Sweetwater Ranch Conditional Use Permit (CU-21-00002)

TO: Kittitas County Hearing Examiner
FROM: Kelly Bacon, Staff Planner
RE: Sweetwater Ranch Conditional Use Permit (CU-21-00002)
DATE: December 9, 2021 (Hearing Date)

Revised Site Plan
 Submittal Date
 6-11-21

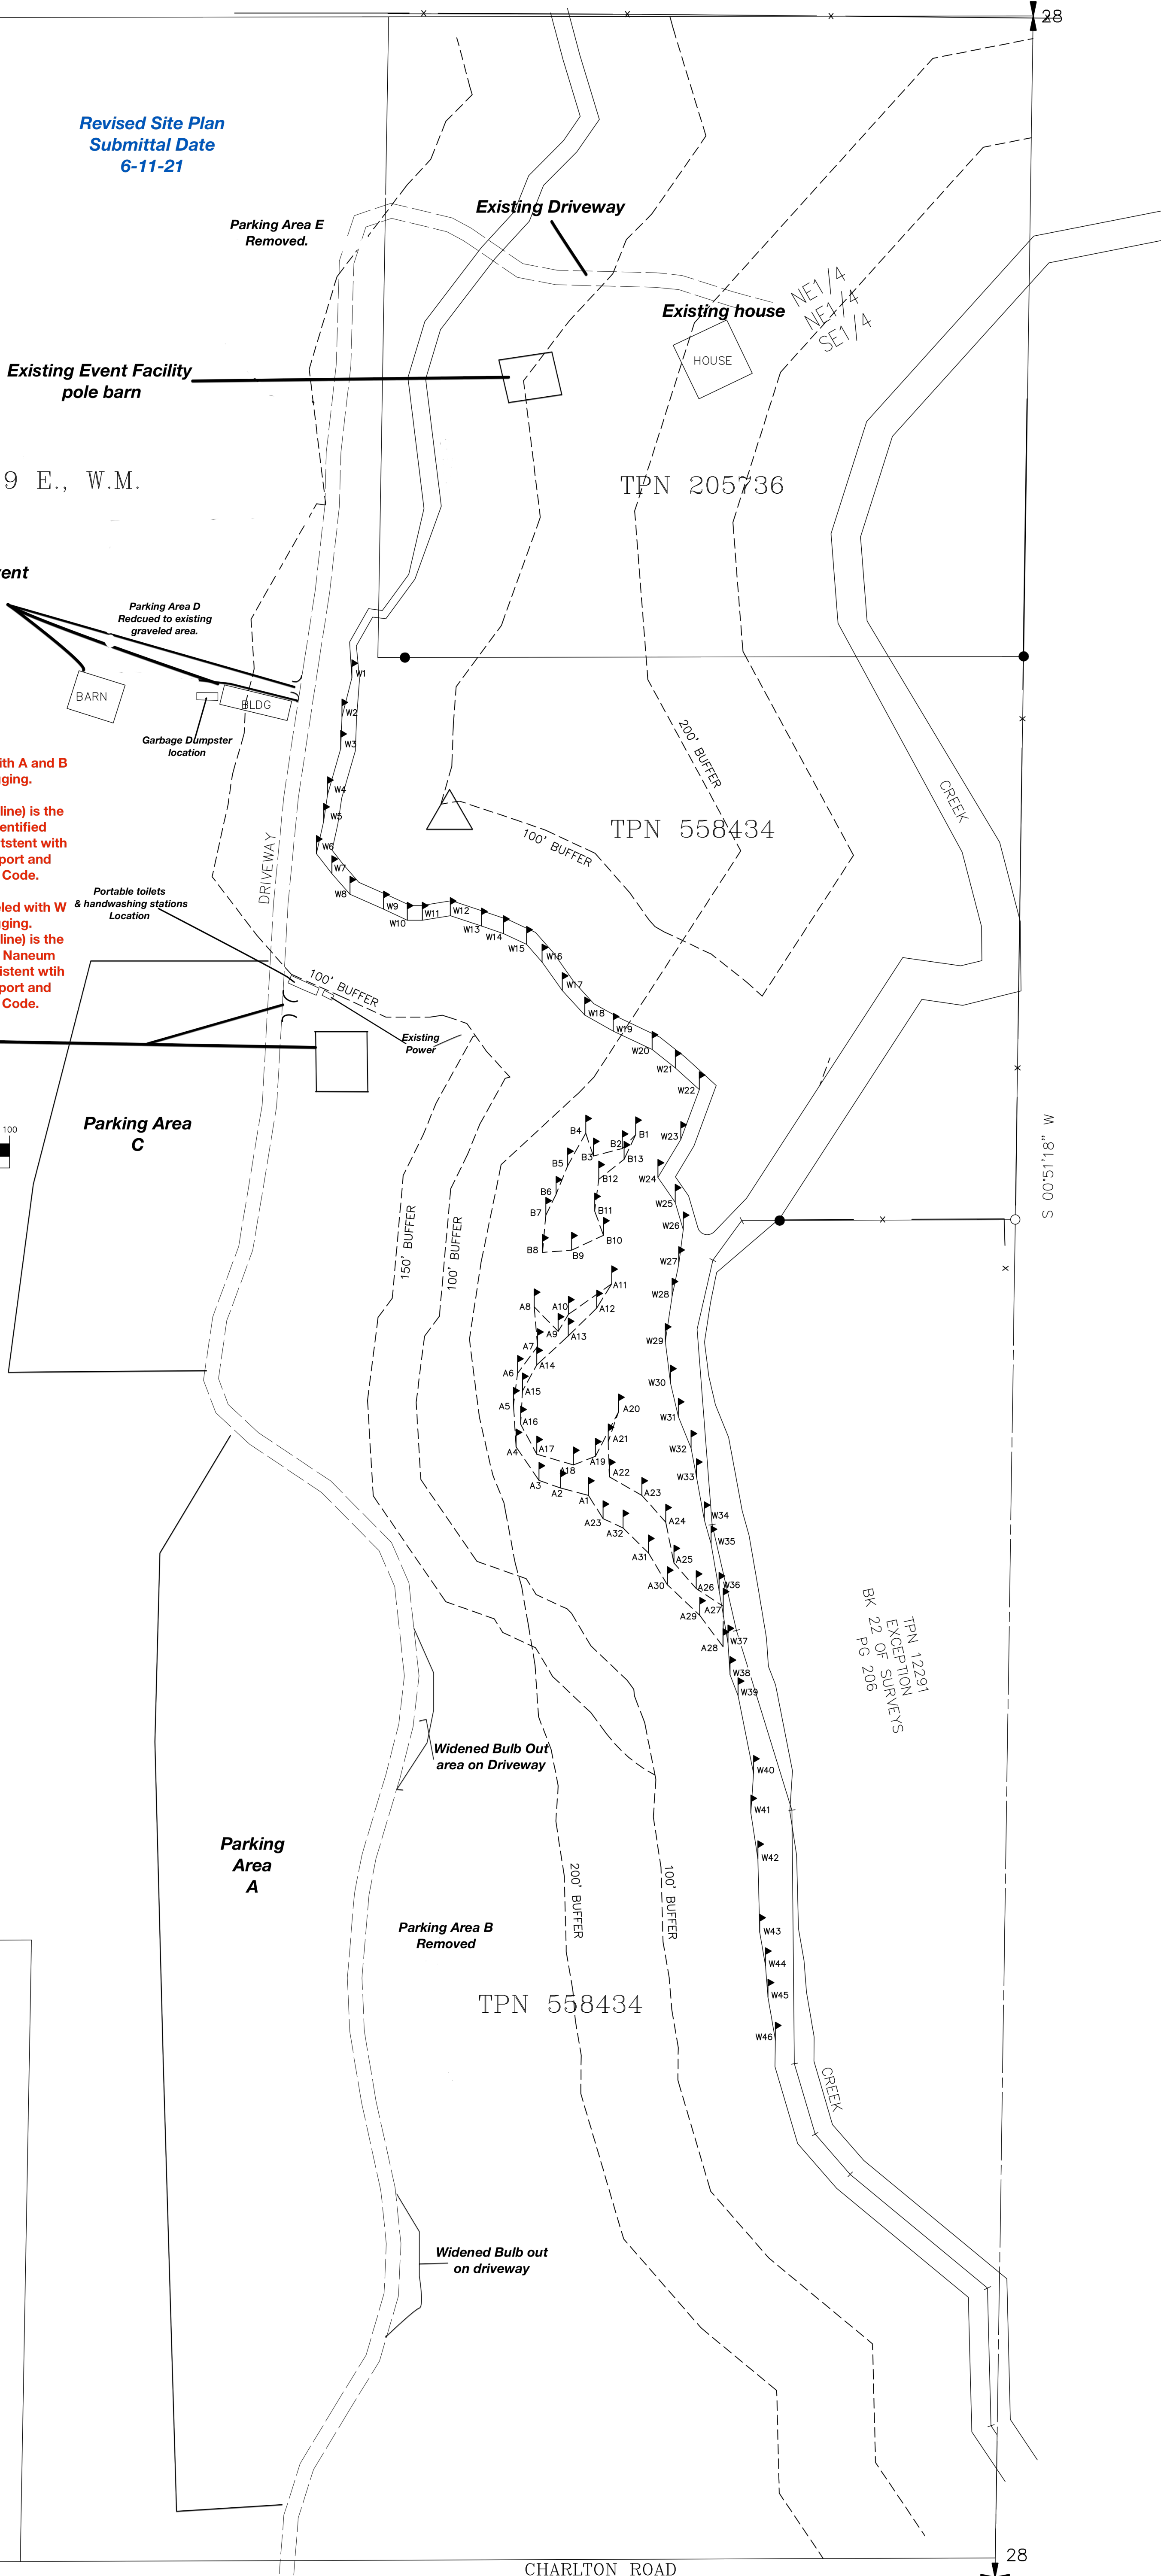
DOE provided comments regarding Shorelands/Environmental Assistance, Water Quality and Water Resources. DOE submitted concerns for the Parking Area B of the site plan and requested a joint onsite visit, as well as concerns for the Critical Areas Report buffer for Category II wetlands, stating that the wetland are associated with Shoreline Jurisdiction and need to be regulated under the Counties Shoreline Master Program (SMP) rather than the Critical Areas code. Concerns regarding potential discharge off-site and the possible need for a NPDES Construction Stormwater General Permit. DOE stated the applicant should contact DOE in regards to water availability in the proposed project area as obtaining a water right is difficult. (See Index #'s 22)

WDFW provided comments in regard to the critical areas located on the property and the possible impacts on fish and wildlife conservation areas, shrub steppe habitat, Naneum Creek and the associated riparian area, Channel Migration Zone, concerns with parking are D and E (and potentially C depending on the extent) all located within the shrub steppe habitat. WDFW requested that parking areas B, D and E be configured to avoid habitat impacts or mitigation for habitat impacts be proposed to offset these impacts. WDFW stated concerns for the proposed trails and fire wising extents and the need for these items to be shown on a site plan for better understanding of the impacts, if the proposed water right impacts on instream flows, WDFW would need to be involved and consulted. (See Index #17-19)
